Part two storey part single storey rear extension, increase in garage height and conversion into additional room

Trebarwith Cottage Barnham Road Eastergate

Thank you for your internet representation made on 21st November 2018 which has been recorded as '**an objection**' with the comments as follows:

EXISTING / PROPOSED ELEVATIONS FLOOR PLANS AND SECTION THROUGH SCALE 1:100

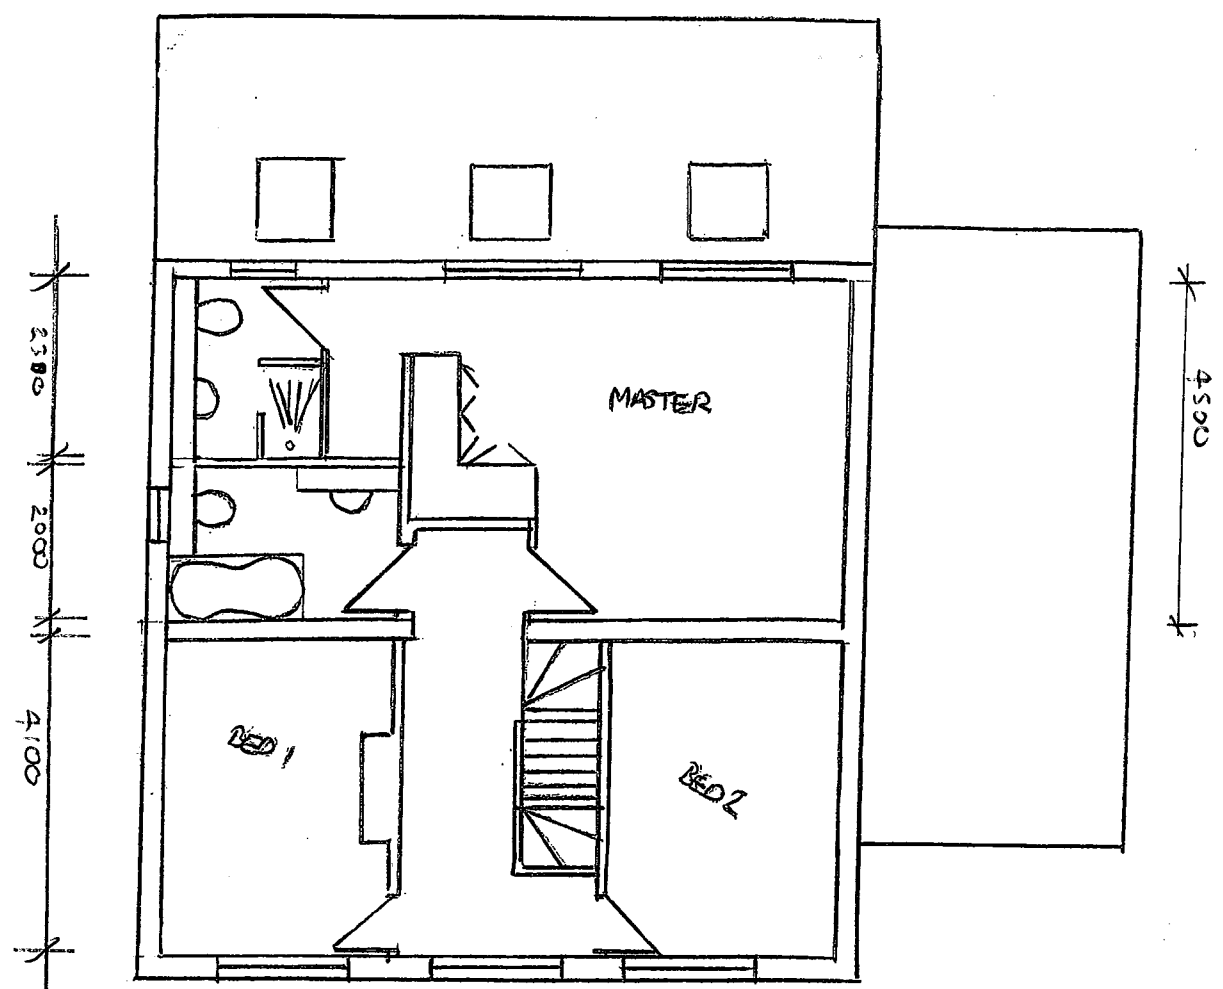
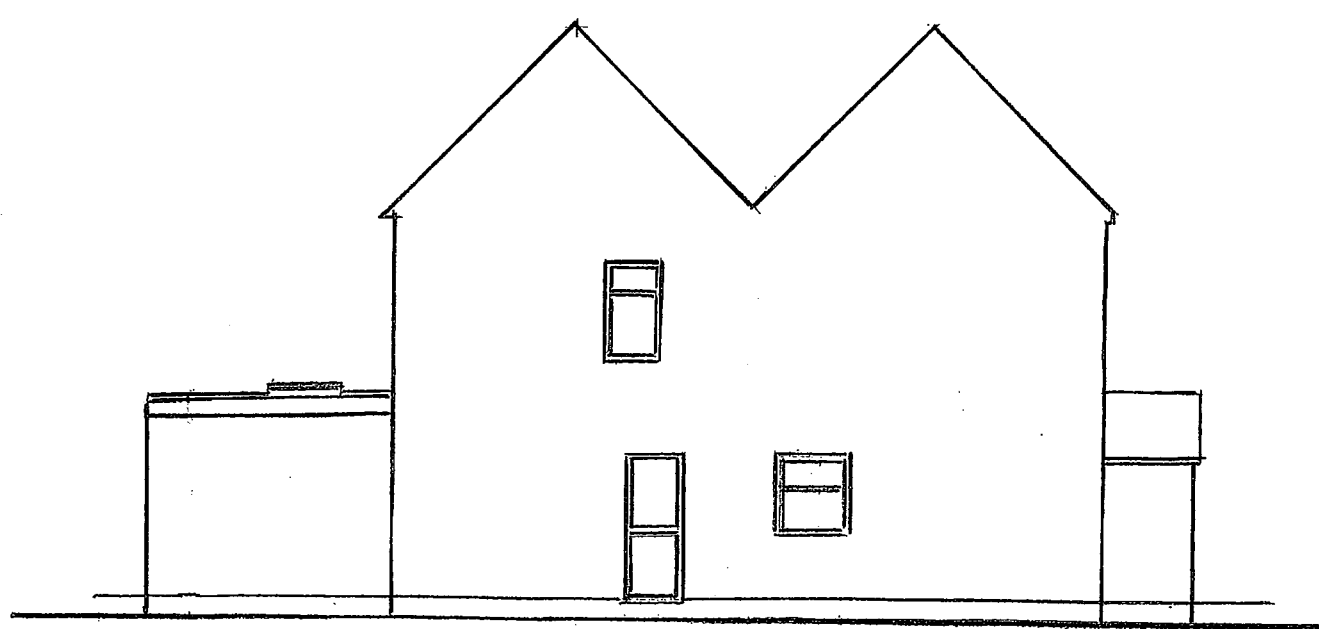
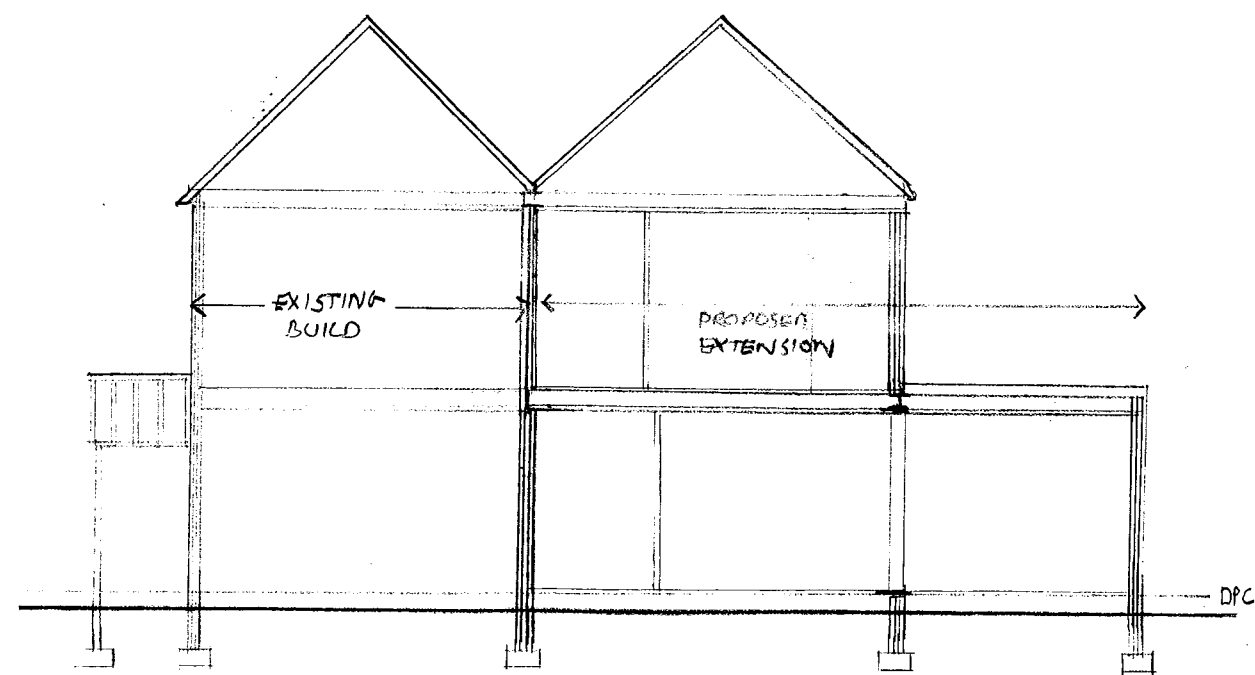
2. If any part of a new building or extension measured in a vertical section perpendicular to a main window wall of an existing building, from the centre of the lowest window, subtends an angle of more than 25° to the horizontal, then the diffuse daylighting of the existing building may be adversely affected.

It can be seen by reference to the Street Scene drawing that this would indeed be the case here.

Having failed this test the guide sets out guidance for a more detailed check to find the loss

of skylight to the existing building. Surely you should require the applicants to have carried out such a detailed analysis to determine whether the proposed extension should be cut back so as not to adversely affect the total amount of skylight which I enjoy and its distribution within my living room?

SITE PLAN SCALE 1:200

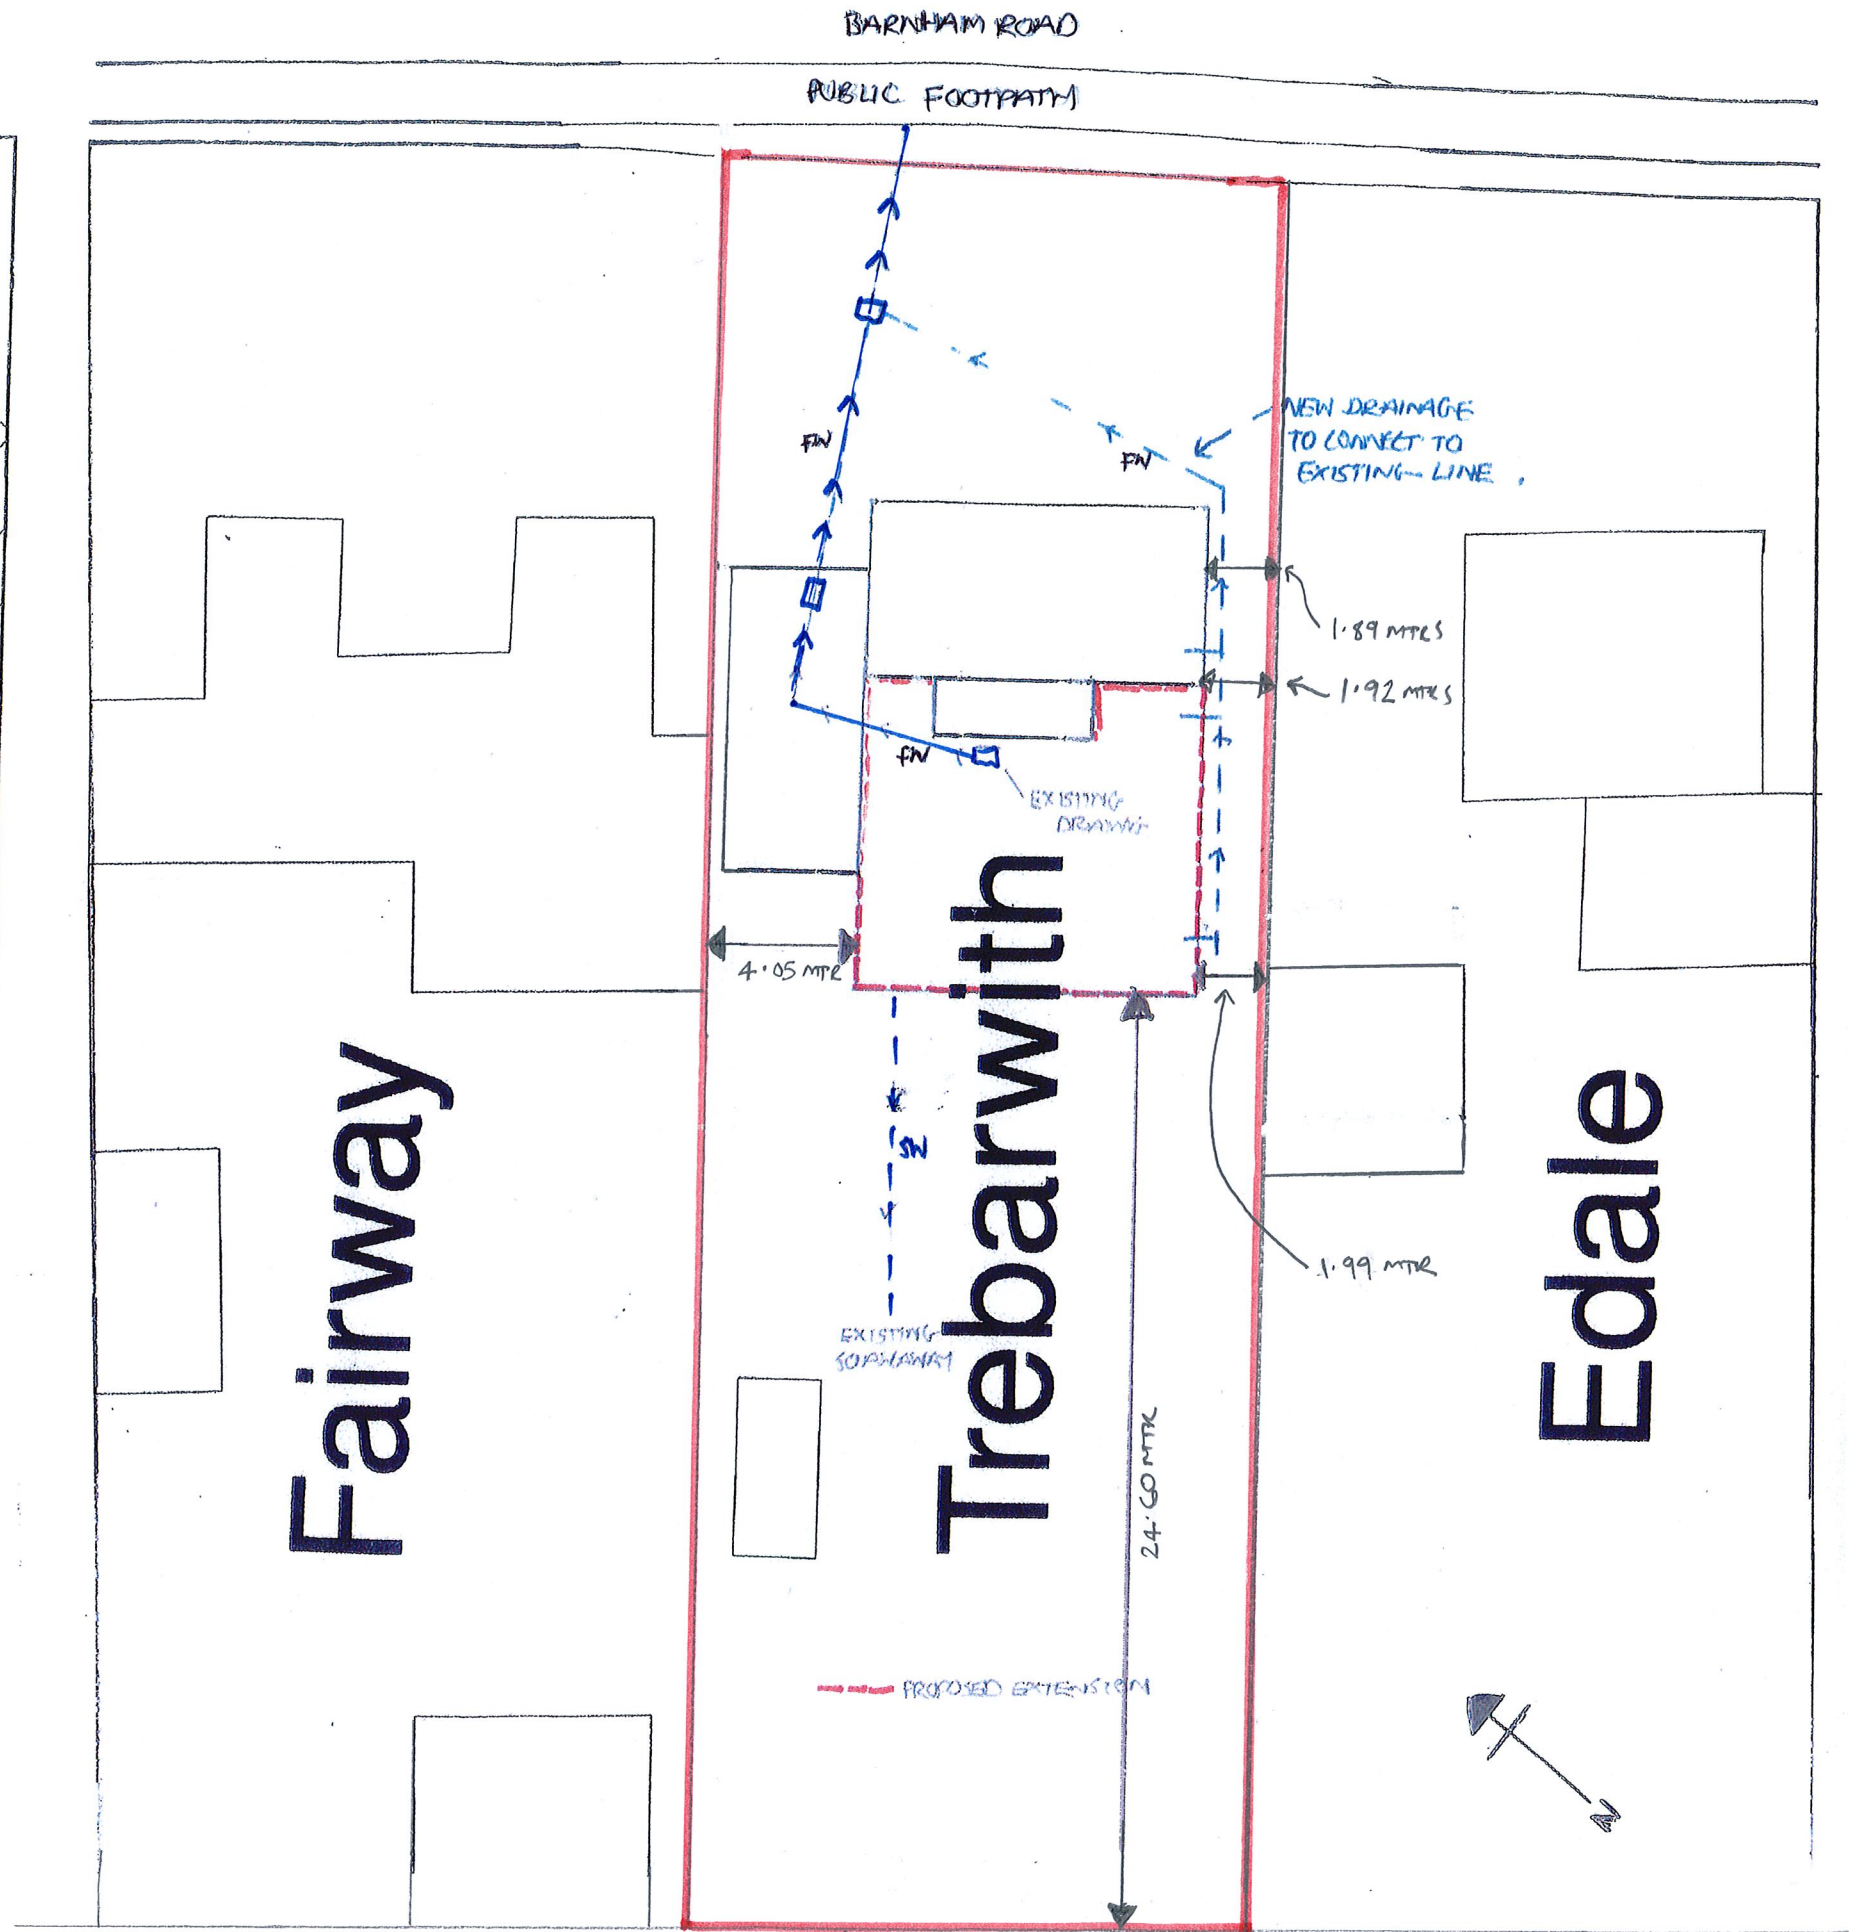
Firstly, the proposed predominately two storey extension and single storey extension is located less than two metres from the boundary between our two properties. The only window in my living room is parallel to, and faces directly, that boundary about 4.25 metres away from it.

The proposed two storey part of the extension is shown extending some 4.8 m to the rear of the existing rear elevation of Trebarwith well beyond the rear corner of my living room as can be seen by reference to the site plan.

As such the daylight in my living room may be adversely affected.
